# **A1 in Northumberland: Morpeth to Ellingham**

**Scheme Number: TR010059**

## **Applicant's Response to ExA's First Written Questions**

<b>Version</b>	<b>Date</b>	<b>Status of Version</b>
Rev 0	January 2021	Deadline 1

Corrected Figure 32 of the Case for the Scheme

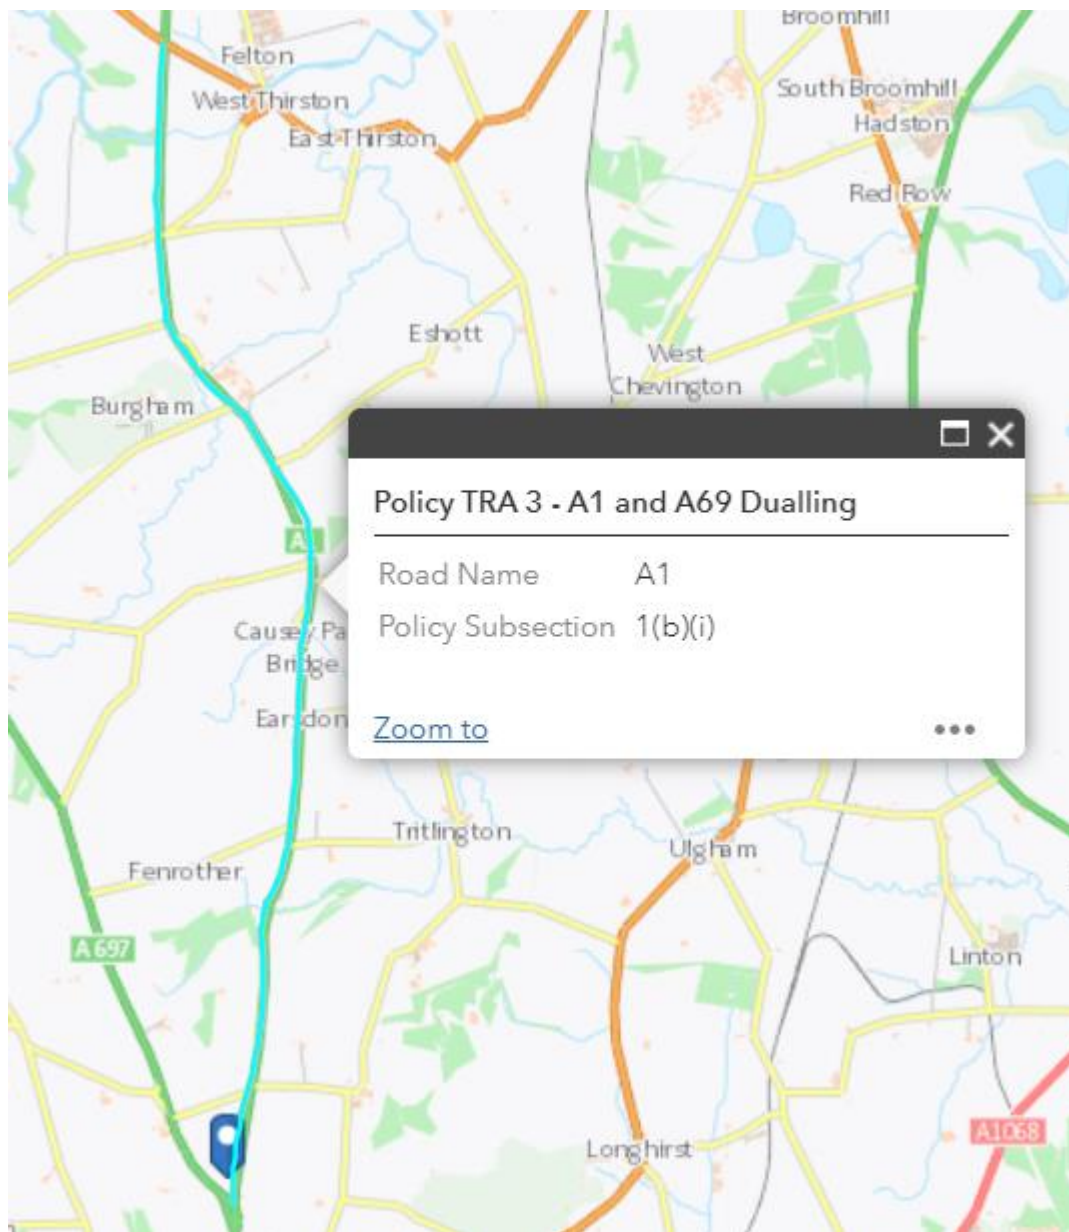
GEN.1.28	Applicant	Figures 32 and 33 of the Case for the Scheme [APP-344] purport to show the extent of Policy TRA3 for Part A and Part B. Is Figure 32 correct in showing the A1 north of Alnwick?	1. Figure 32 in the Case for the Scheme [APP-344] is incorrect. An updated version of Figure 32 that does illustrate the point is provided at Deadline 1 at Appendix GEN.6.
GEN.1.29	Applicant NCC	Figure 34 of the Case for the Scheme [APP-344] is titled 'Inner and Outer Green Belt Boundary Preferred Options Map' sourced from the NCC Morpeth Outer Green Belt Boundary Report, October 2013. It shows existing Green Belt and Proposed Green Belt Extension. Figure 7.10 of the ES [APP-097] shows the existing Green Belt as for Figure 34 and Saved Policy S5 Green Belt Extension. Paragraph 6.4.1 references Policy S5 of the Structure	<ol style="list-style-type: none"> <li>1. The Scheme would involve development within the Green Belt as defined in Policy S5 of the Structure Plan and in the emerging NCC Local Plan. However, the section of the Scheme which involves development within the Green Belt is limited to Part A in the area near to Morpeth. Policy S5 is a saved policy from the Northumberland Structure Plan that was published in 2005. As a 'saved' policy it is considered to form part of the development plan for determination planning applications.</li> <li>2. Policy S5 set out a general intention to extend to the north the existing Green Belt around Morpeth, which the broad geographic boundary described in the text of the policy.</li> </ol>
